Application No: A/43/22/PL
Site Address: Land East Of Roundstone Lane Angmering BN16 4AL
Description of works: Variation of condition following grant of A/3/21/PL relating to Condition No 1 - approved plans.

Thank you for your internet representation made on 1st April 2022 which has been recorded as an objection with the comments as follows:

Soft Landscape Proposals Plan
Sheet 2 of 2

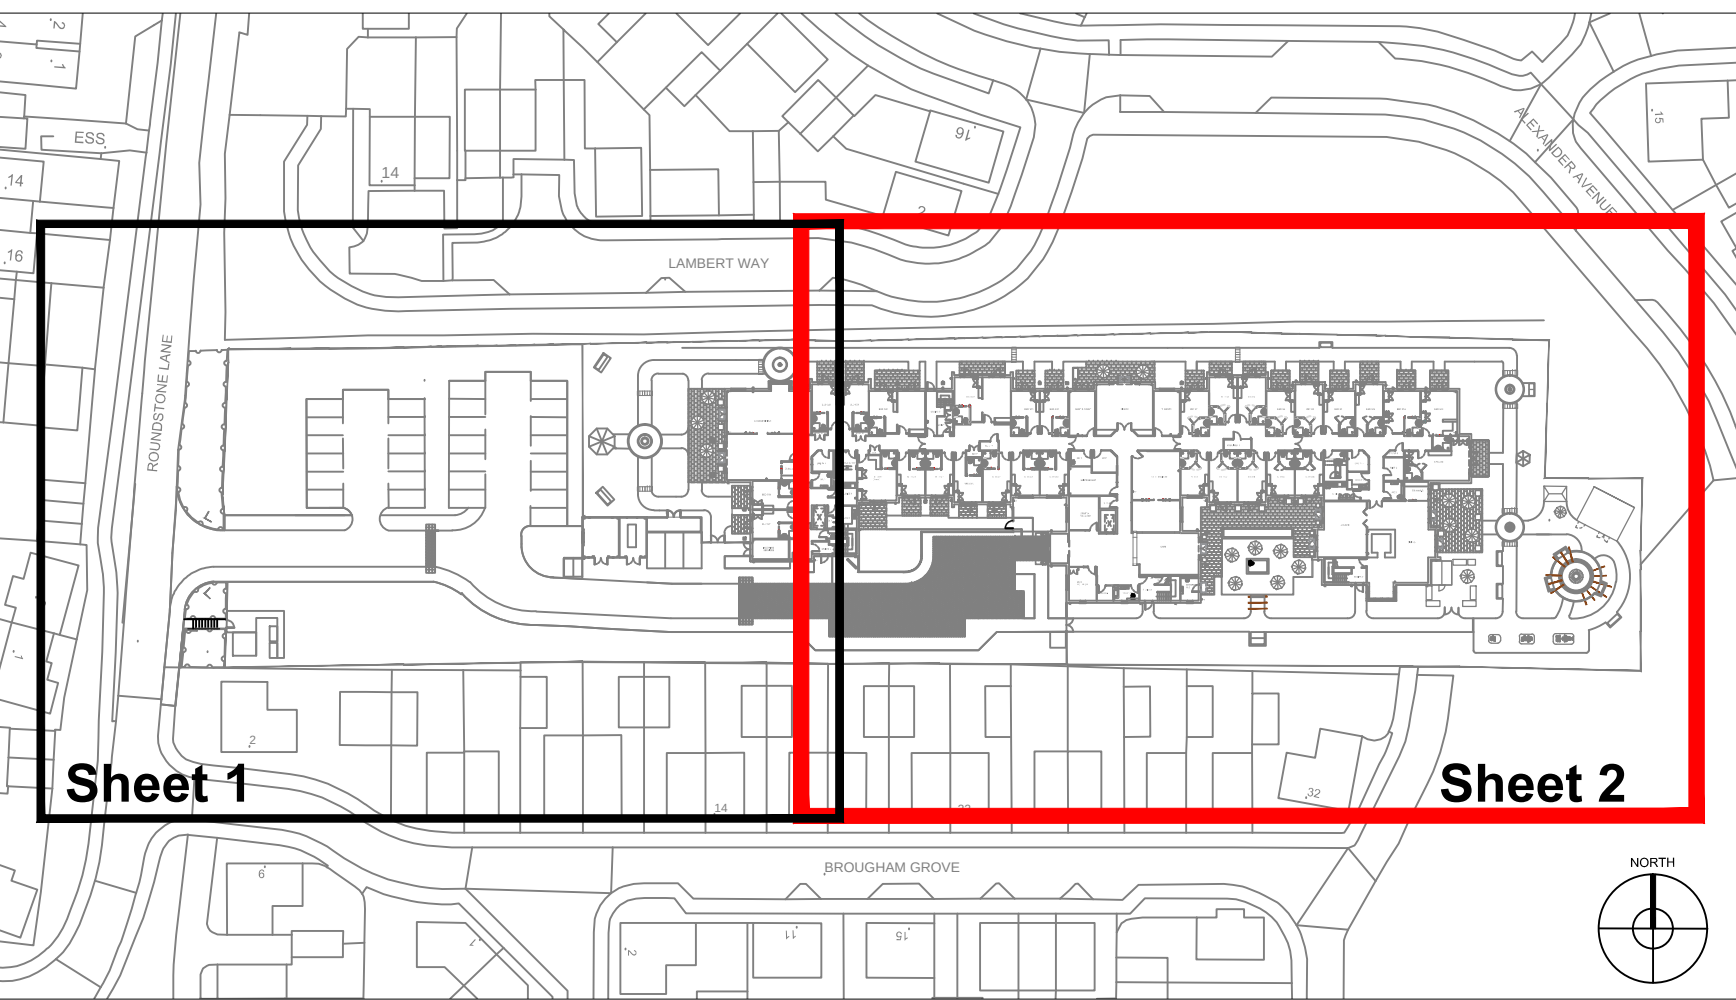
I object to the plans that seek to remove the established conifers from the front of the property. There has been an enormous number of mature trees already removed from this site, all of which at one point were protected. The trees to the front of the property had been preserved and are intended to screen a very large building from the road, thereby preserving the visual amenity. Additionally, further screening is required to west of the electricity substation to ensure adequate screening to visually unattractive equipment.
